Planning Objection

Application Reference: 2023/62/91261/W

**Land at
Alexandra Road West
Paddock
Huddersfield
HD3 4EX**

June 2023

- TARMAC PRIVATE DRIVE CONSTRUCTED TO ADOPTABLE STANDARDS
- BLOCK PAVING
- GRASSED/ LANDSCAPED AREAS
- PROPOSED RETAINING WALLS FACED IN STONE
- 0.9m HIGH STONE BOUNDARY WALLS
- INDICATIVE FOUL DRAINAGE LAYOUT (TO SPECIALISTS DESIGN)
- INDICATIVE SURFACE WATER DRAINAGE LAYOUT (TO SPECIALISTS DESIGN)

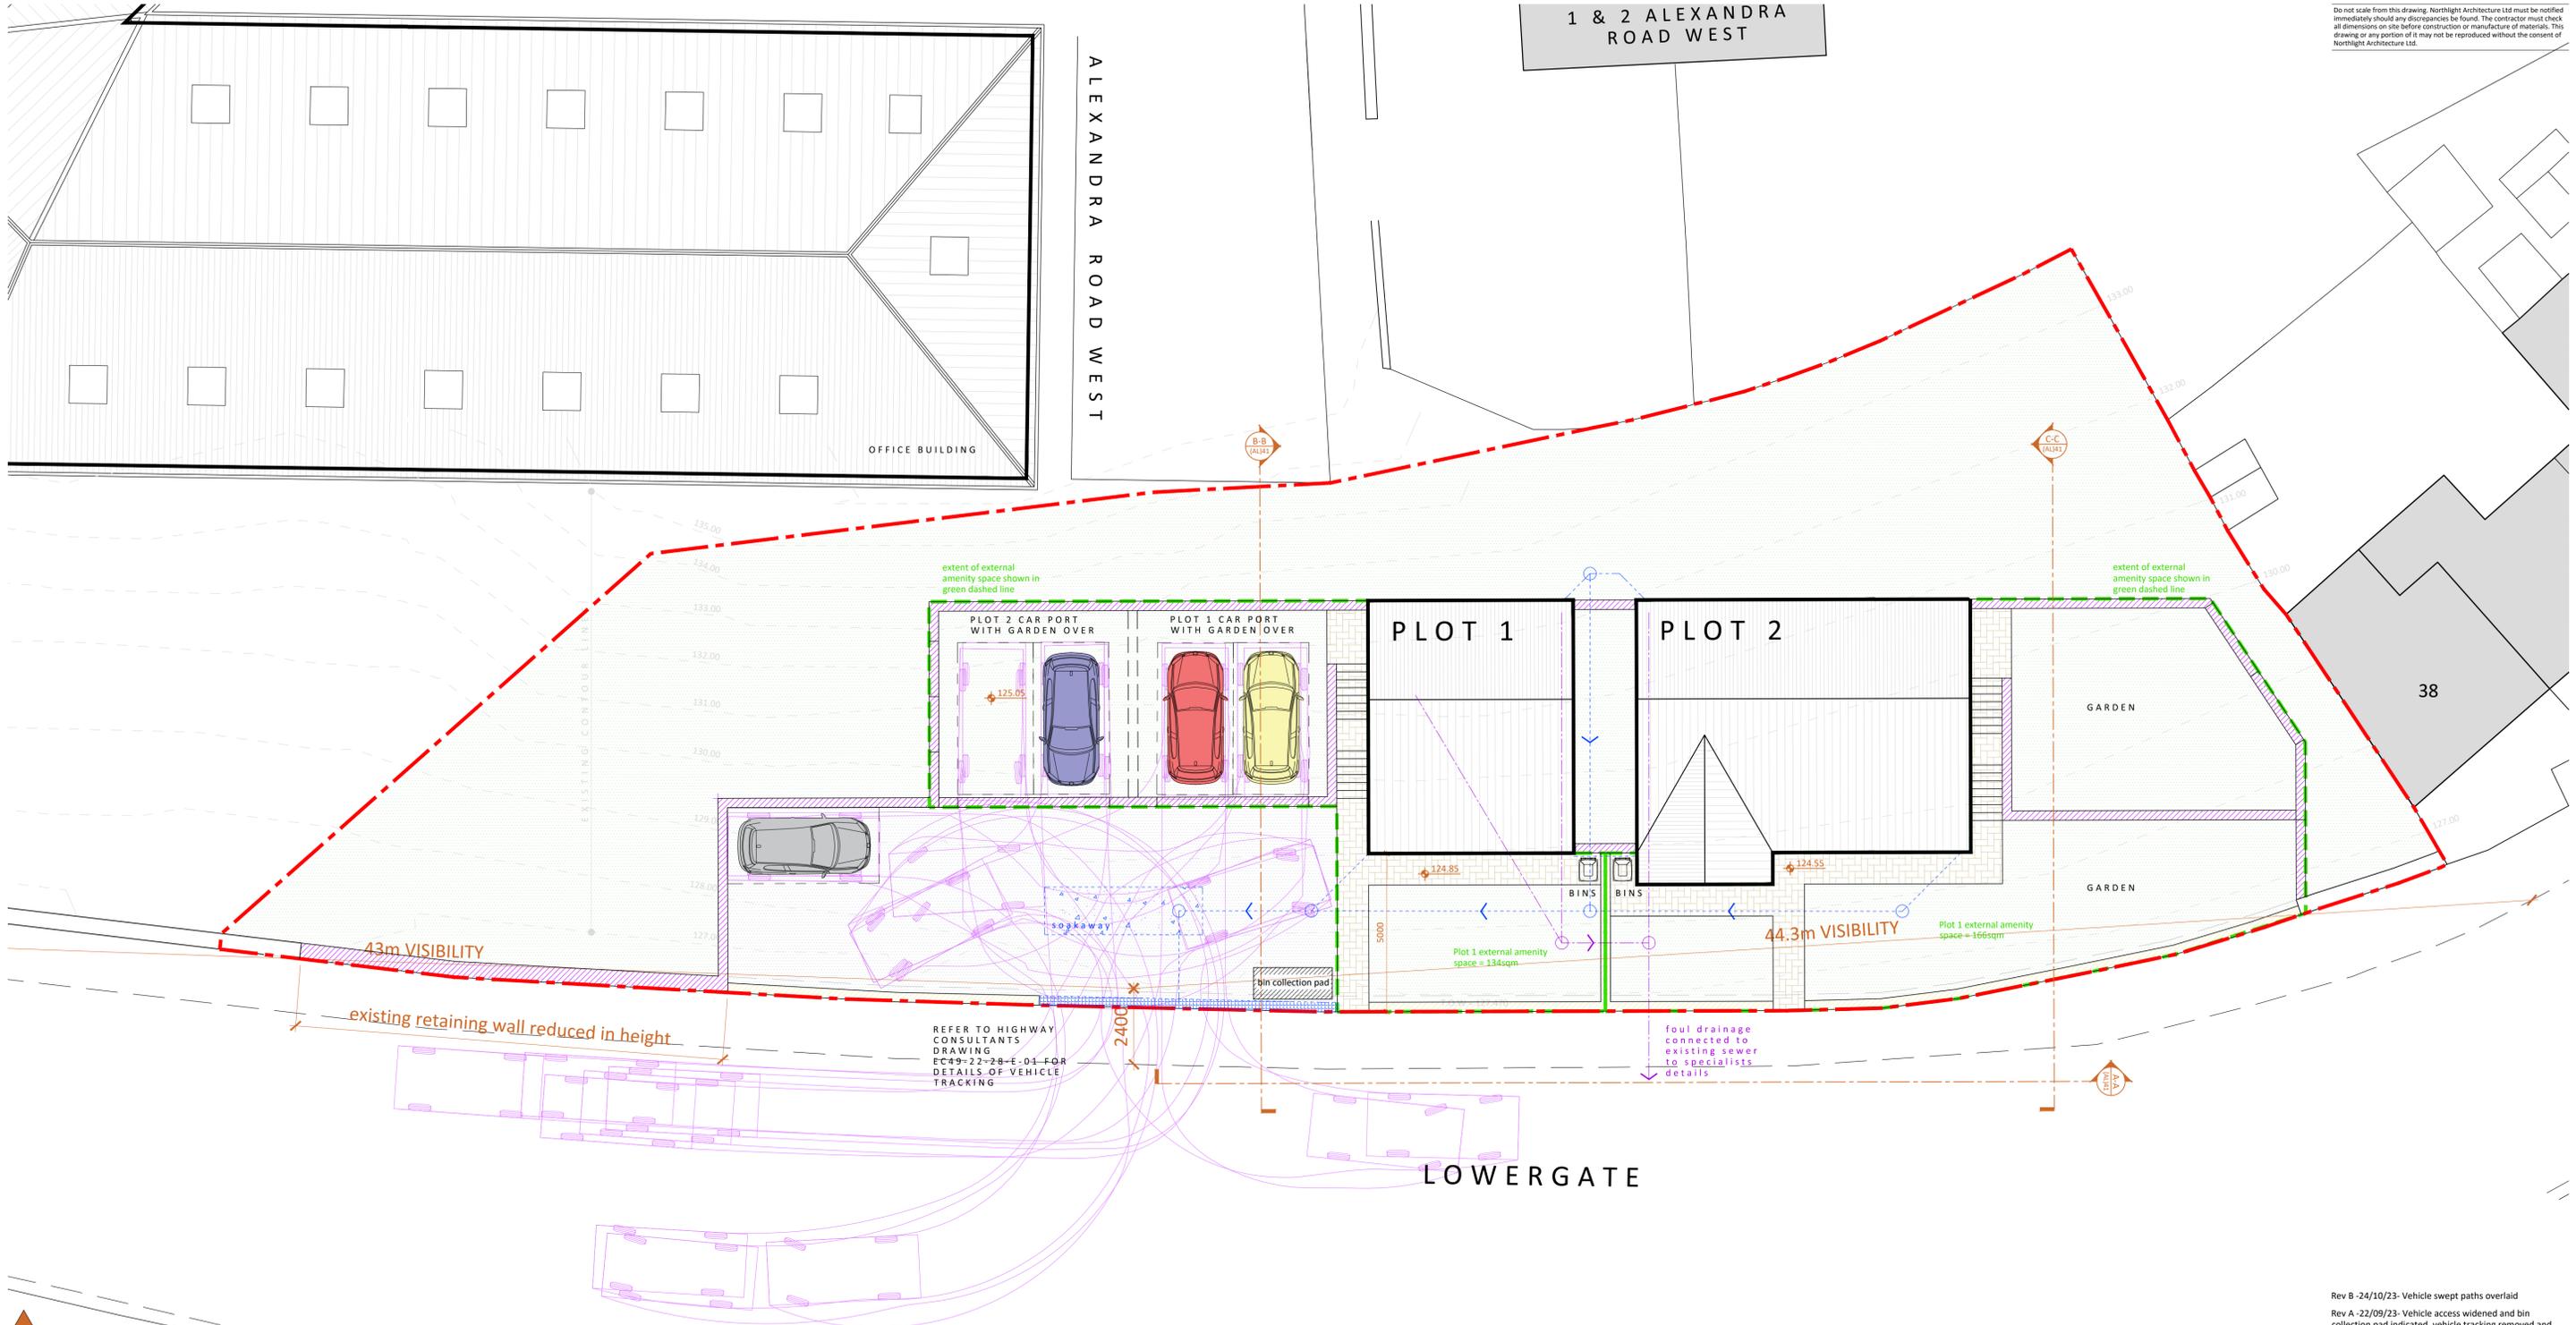
- 2.10 **Foul Sewage:** The application forms details that foul sewage is to be disposed of via the Mains Sewer and identified the plan reference AL(40) as having details of the existing system. Having reviewed the plan we once again note that the plan shows an indicative foul drainage layout “to specialists details”, but no further information had been submitted in regard to the said specialists’ details. As this is a full planning application, as opposed to an outline proposal, we consider there should have been a Drainage Strategy submitted with the application clearly showing the proposed methods and routes of foul and surface water drainage, and rates of flow from the site.

- 2.14 We note a swept path analysis has been shown on the plan reference AL(40). However, it is unclear what vehicle type that is for; albeit it looks to only relate to a smaller vehicle, and in fact only relates to one of the proposed five parking bays. It does not demonstrate safe access and egress from all five spaces now being proposed. Confirmation is also sought that the proposed reduction in parking spaces from the previously proposed 6 to 5 remains policy compliant for two dwellings.

- **Swept Path Analysis:** As detailed above, a Swept Path Analysis should be submitted demonstrating that there is sufficient turning space within the site for a standard Kirklees RCV, and at the very least clarification of the vehicle shown on drawing AL (40) to ensure that the site and all proposed vehicle parking
